Ribble Valley Borough Council
Housing & Development Control

Your ref: 3/2024/0096
Our ref: D3.2024.0096
Date: 20th May 2024

Application no: **3/2024/0096**

Proposal: **Proposed replacement boundary fencing using 2.0m/2.4m high welded mesh fencing. Creation of new vehicular access from Little Lane, two pedestrian gates from Preston Road (non-automated), one automated vehicle and pedestrian gate from Preston Road and one automated pedestrian gate from existing barrier car park area.**

Highway Details

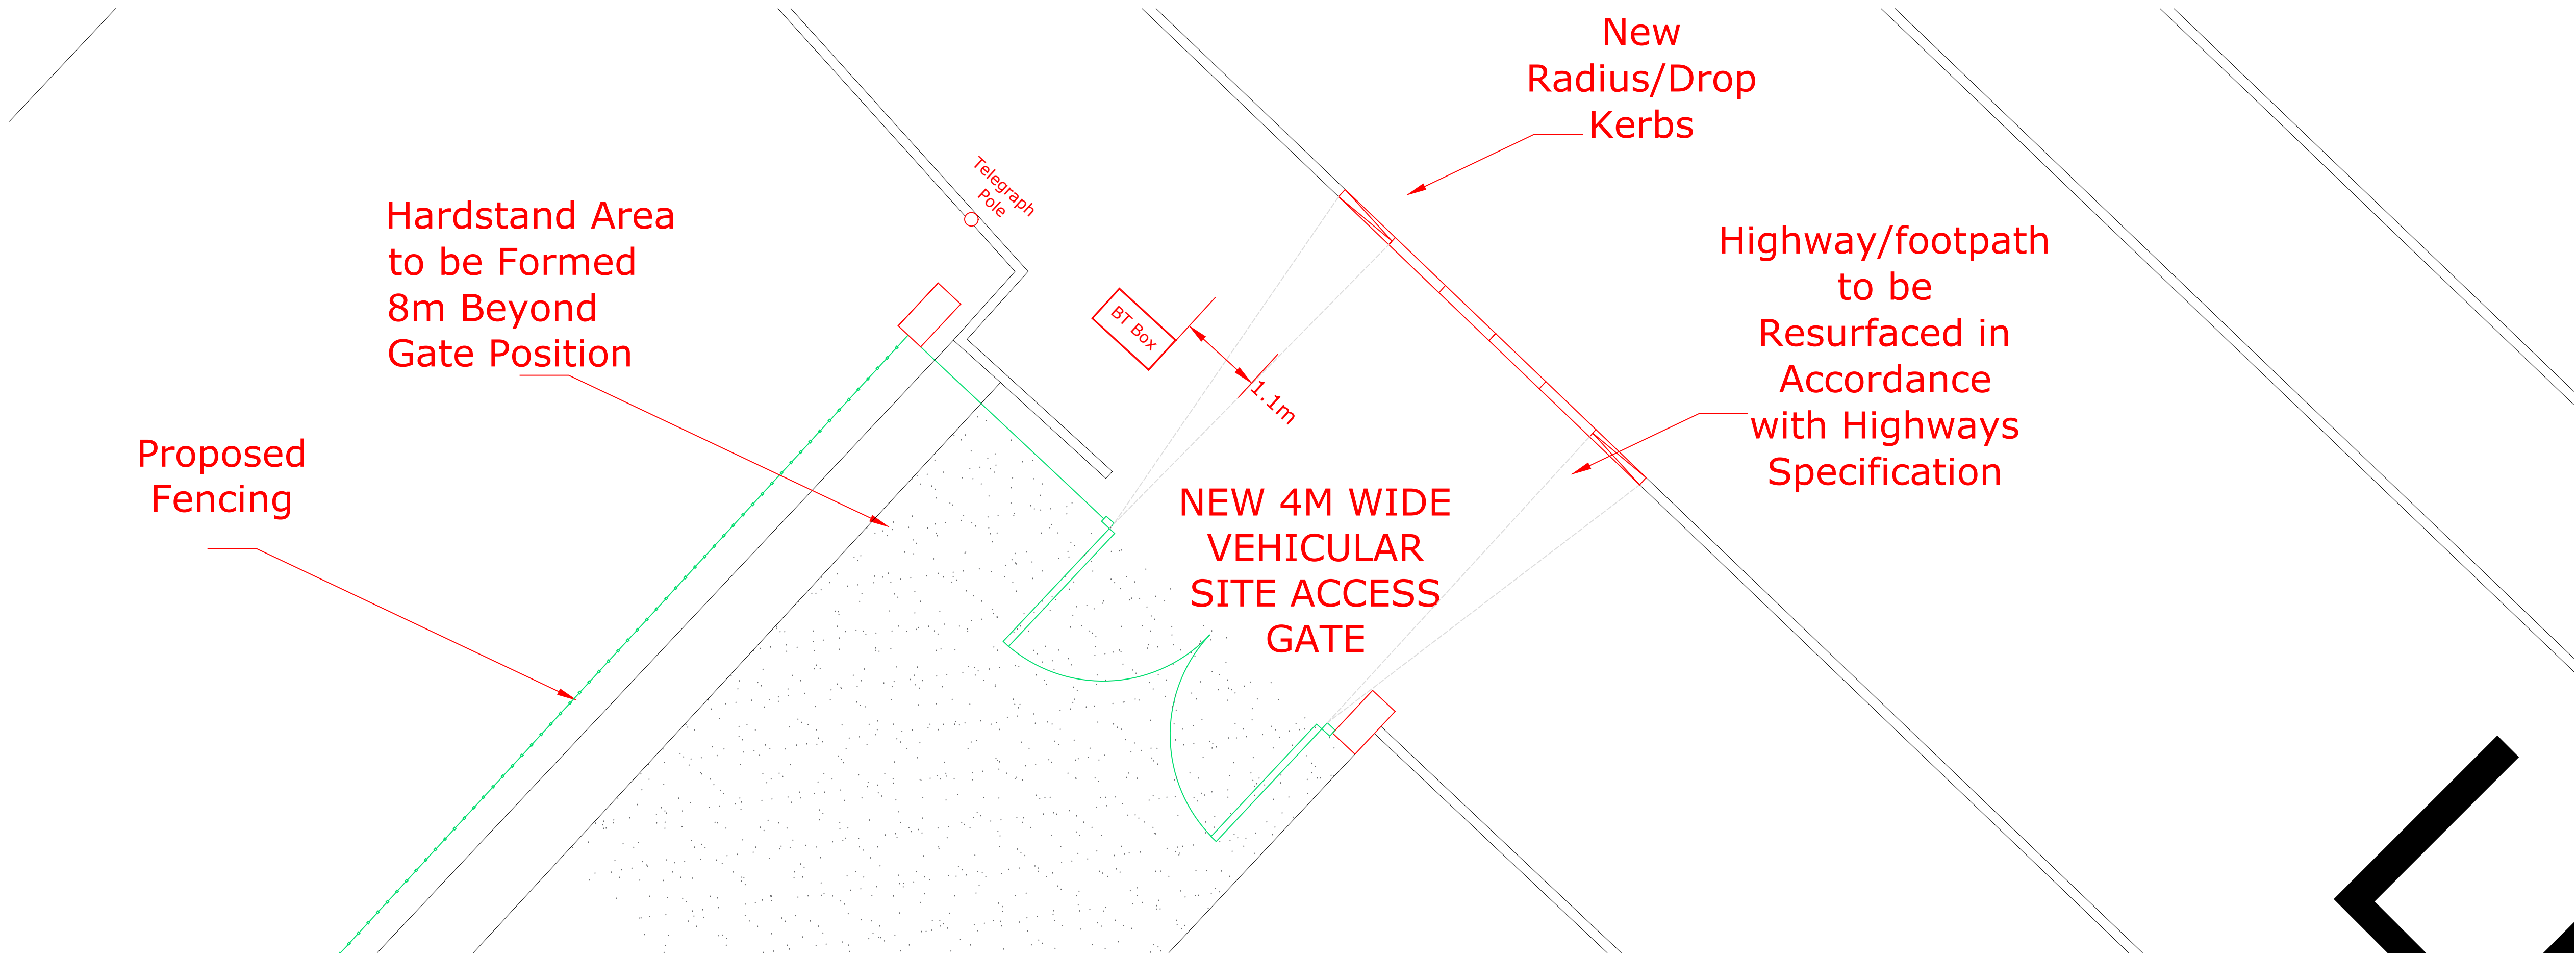
As already mentioned, BT Openreach have been consulted on the application and have no objection with the service chamber located adjacent to the access on the existing footway being strong enough for vehicles to drive over and the positioning of the existing

telegraph poles located adjacent to the access and the field are not compromised. Given these reasons, the LHA have no objection to the creation of a new access. But will require a Section 278 Agreement to be reached following the creation of the access and the proposed improvements to the footway fronting the access as shown on LeaHough drawing number BS.23-277-04 Rev B titled "Highway Details".

3.The development hereby permitted shall not be occupied until such time as the access has been surfaced with tarmacadam, or similar hard bound material (not loose aggregate) for a distance of at least 5 metres behind the highway boundary and, once provided, shall be so maintained in perpetuity.

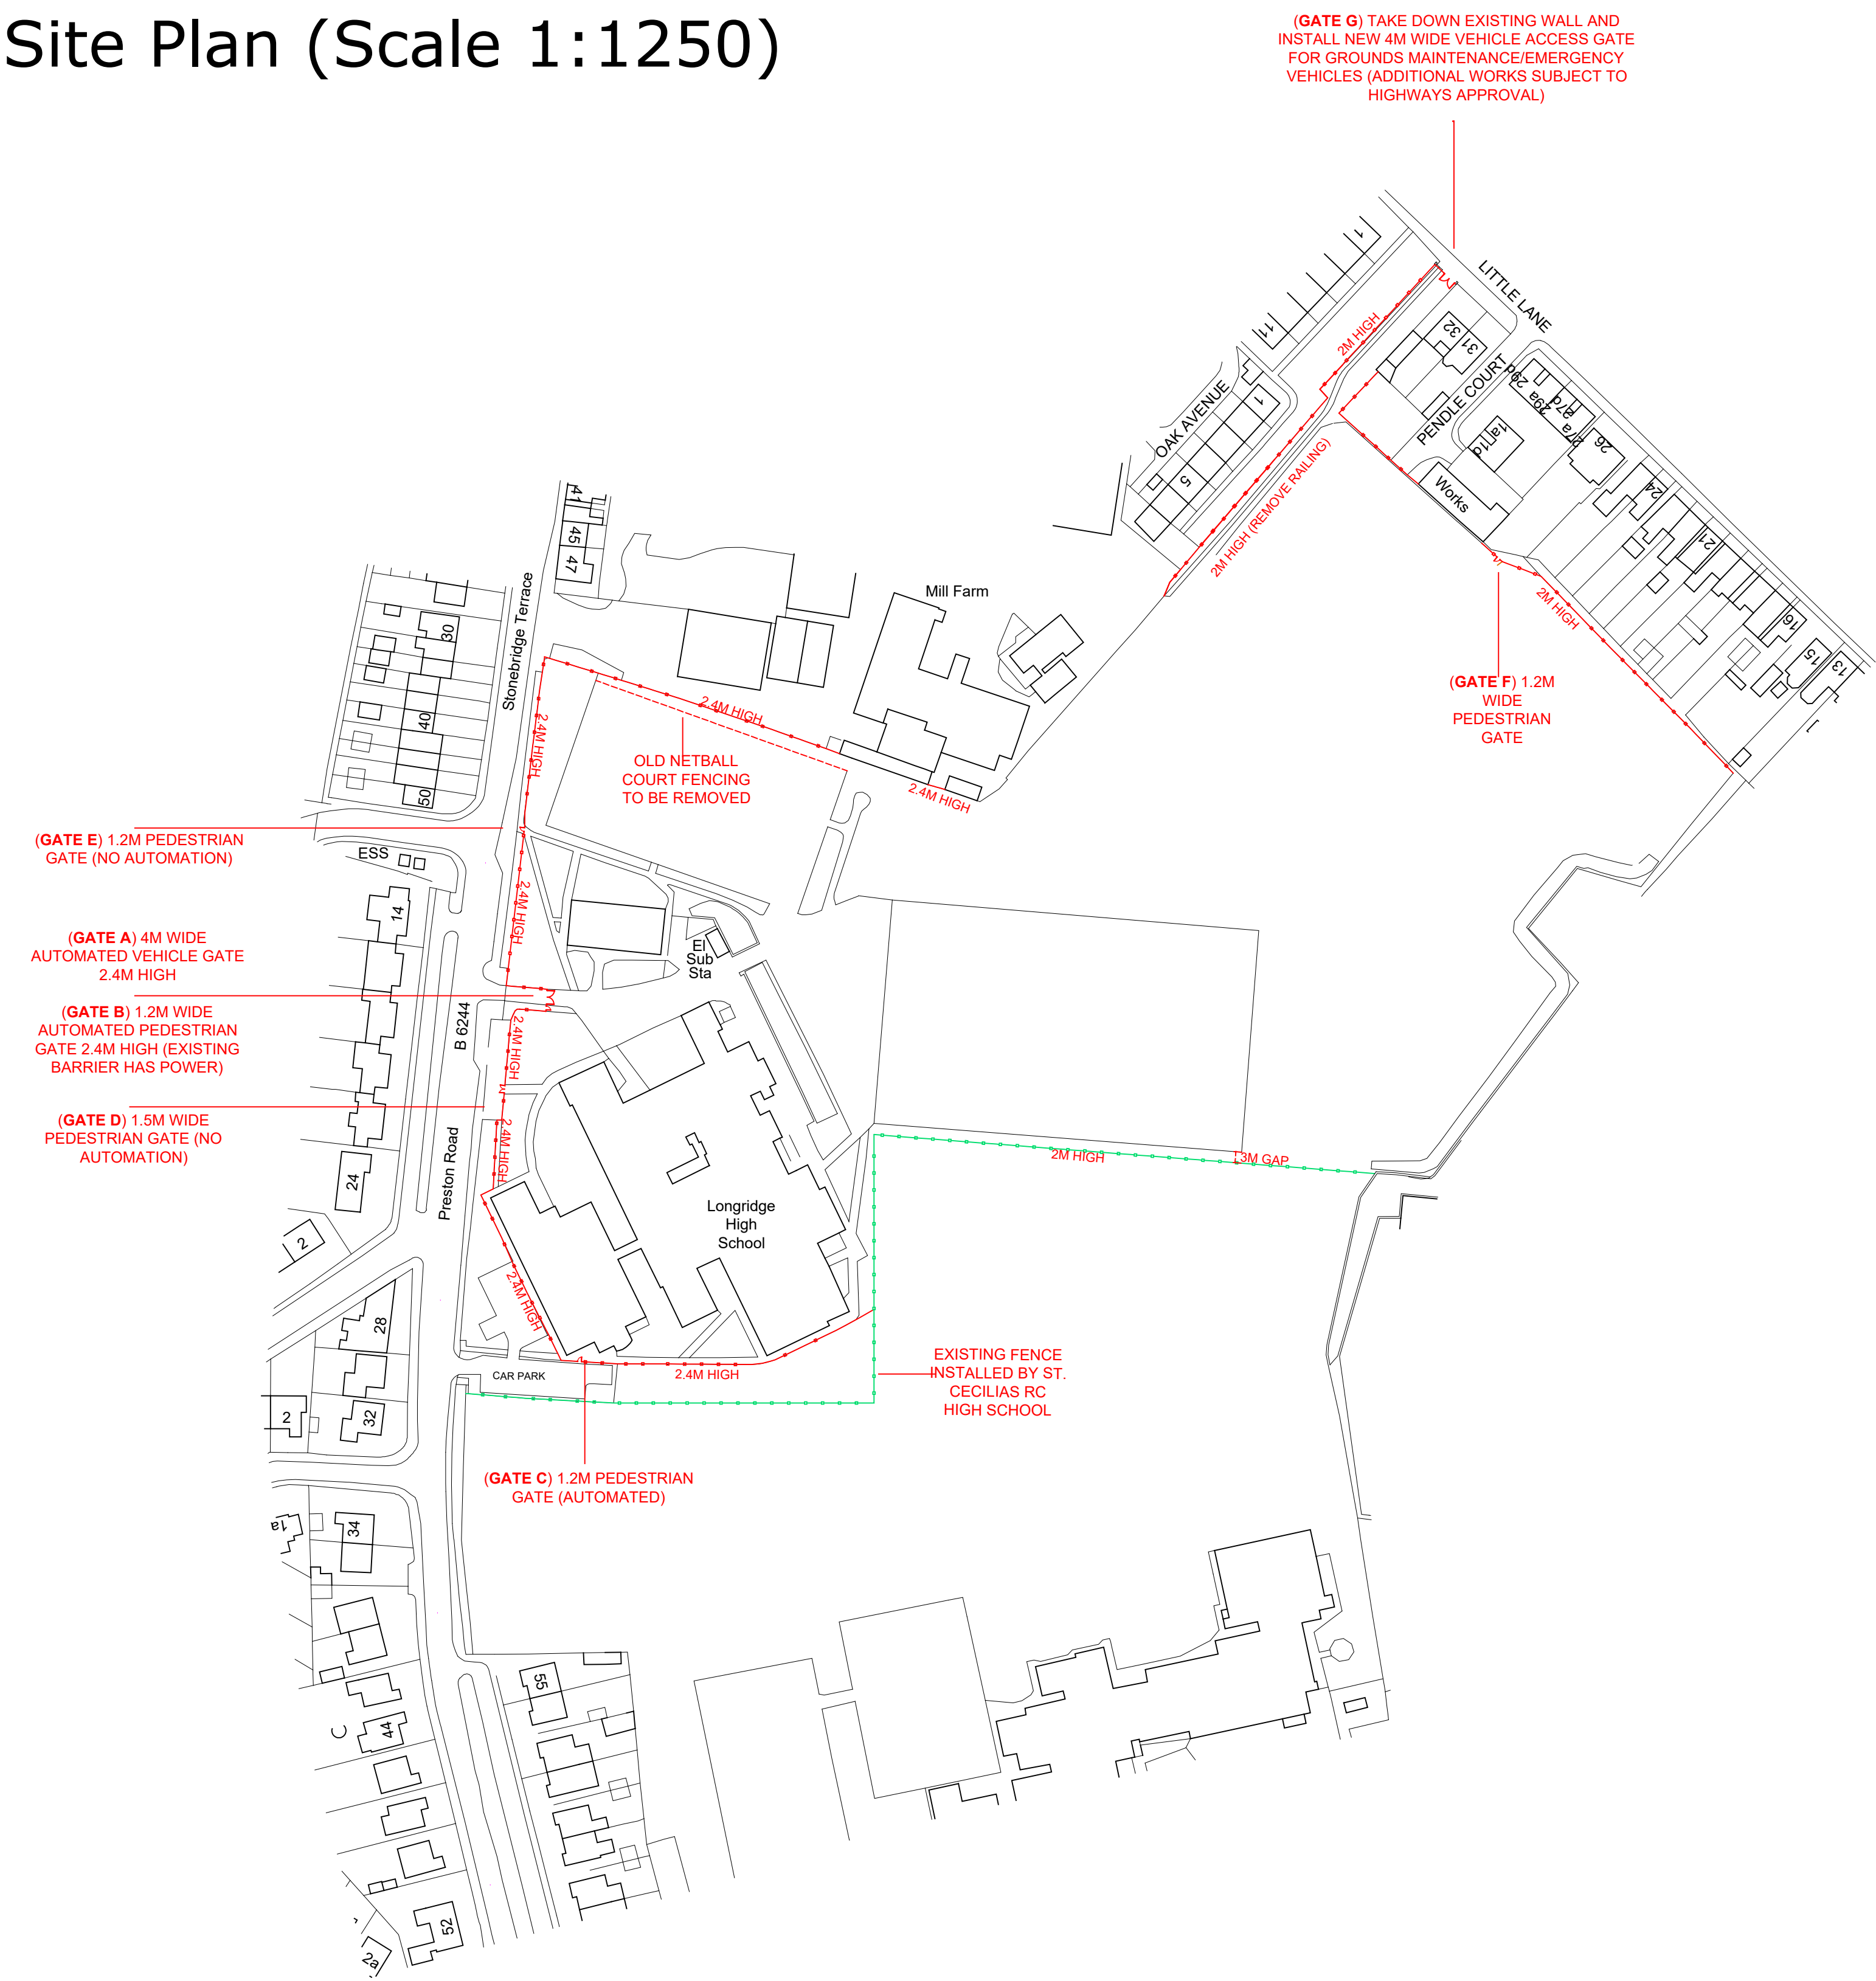
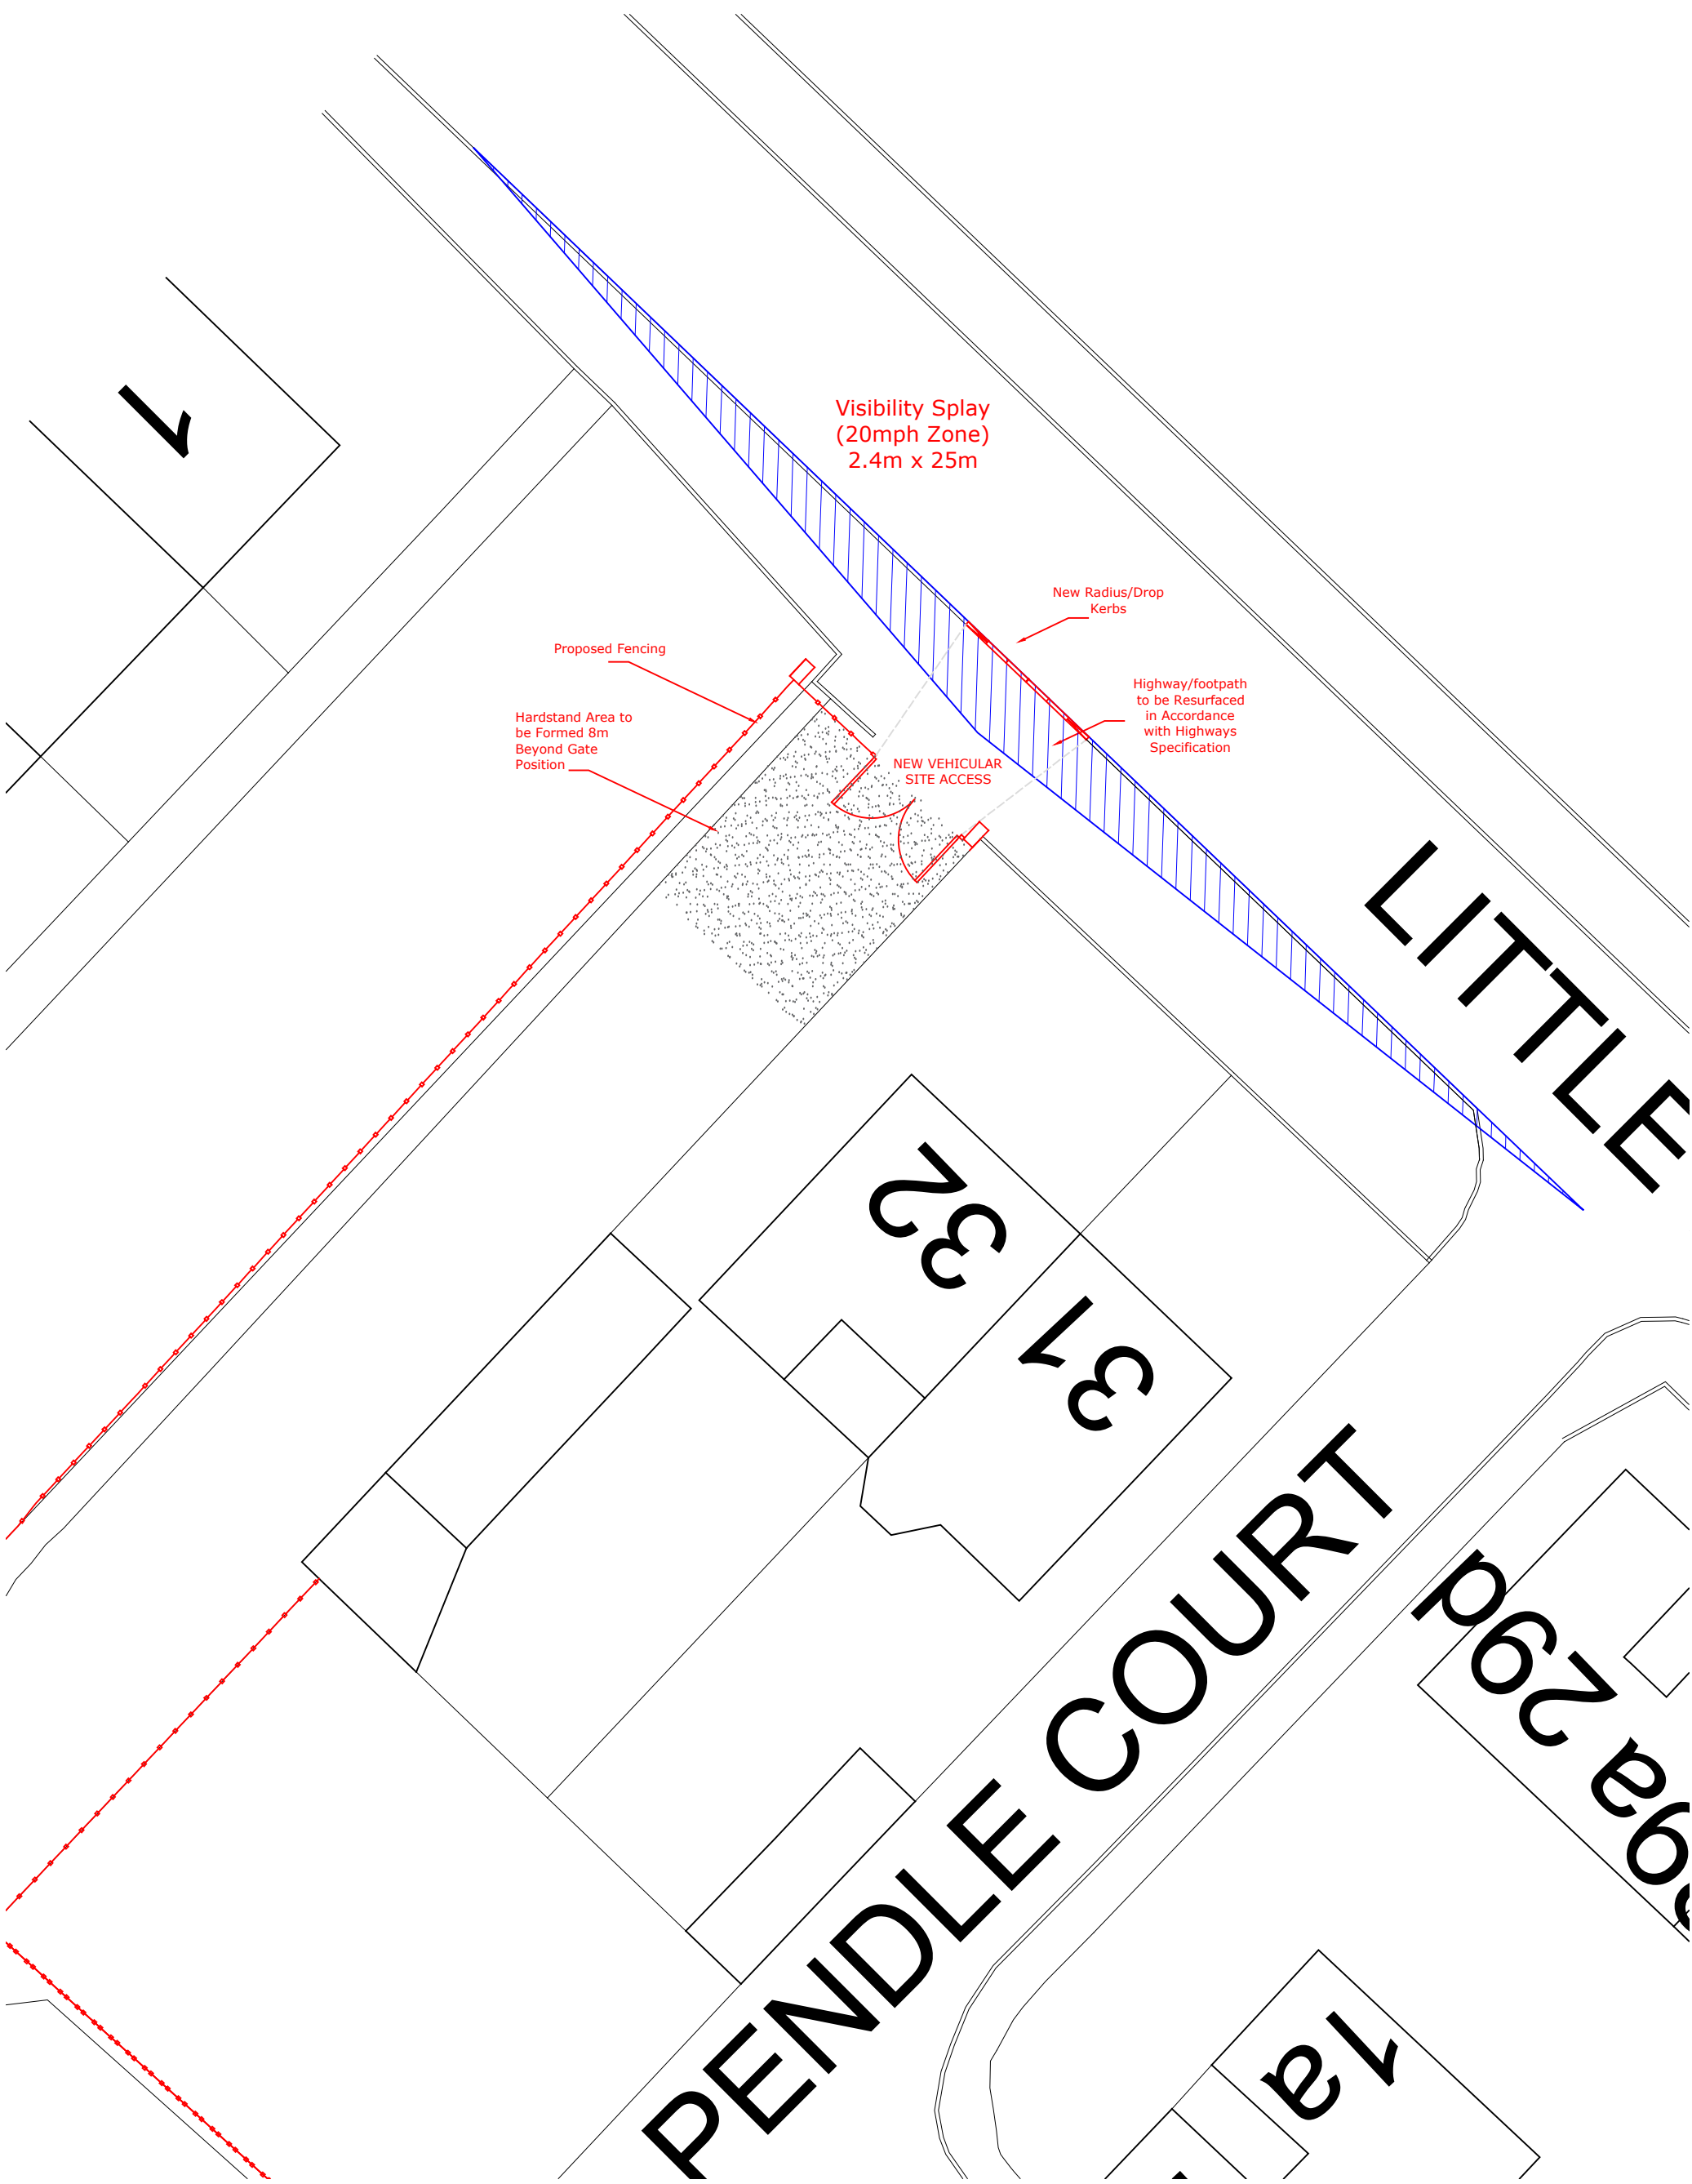
To support the creation of the access and following further information in the guise of an Operation Statement, the Agent has submitted a swept path drawing of transit van with a trailer entering the site, using the internal access track and exiting the site in a forward gear. The LHA are satisfied that the access and the track is suitable for these movements and welcome the track being adequately surfaced for a minimum of 8m behind the highway boundary, as shown on LeaHough drawing number BS.23-277-02 Rev C titled "Site Plan with Proposed Fencing."
